City of Portland, Maine - Building or Use Permit Application

Permit No: 04-0693	Issue Date: JUL 22 2004	CBL: 045 A011001
-----------------------	----------------------------	---------------------

Past Use: Six unit	Proposed Use: 7 unit: requesting legalization of existing non-conforming unit	Permit Fee: \$75.00	Cost of Work: \$0.00	(CEODistrict): 2
		FIRE DEPT: <input checked="" type="checkbox"/> Approved <input type="checkbox"/> Denied	INSPECTION: Use Group: 22 Type: 53 7/21/04

Proposed Project Description: legalization of 1 existing non-conforming unit	Signature: <i>[Signature]</i>	Signature: <i>[Signature]</i>
PEDESTRIAN ACTIVITIES DISTRICT (P.A.D.)		
Action: <input type="checkbox"/> Approved <input type="checkbox"/> Approved w/Conditions <input type="checkbox"/> Denied		
Signature:		Date:

Dedicated
entrance to Unit #7 Unit #7 950 s.f. 2nd floor

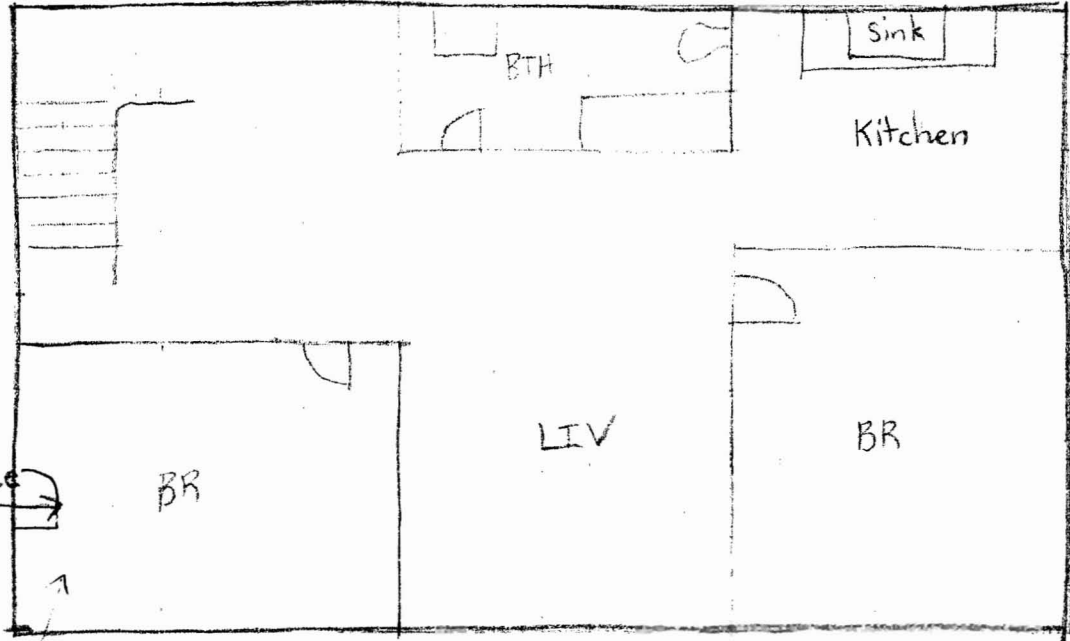
- 1) The Inspections Division has two conditions that shall be completed before an occupancy permit can be issued.
 - 1) Unit 7 will have a new dedicated egress at the front of building.
 - 2) Unit 6 will have a dedicated egress out the rear of the building.
- 2) This property shall remain a seven (7) family dwelling after the issuance of this permit. Any change of use shall require a separate permit application for review and approval.
- 3) ANY exterior work requires a separate review and approval thru Historic Preservation
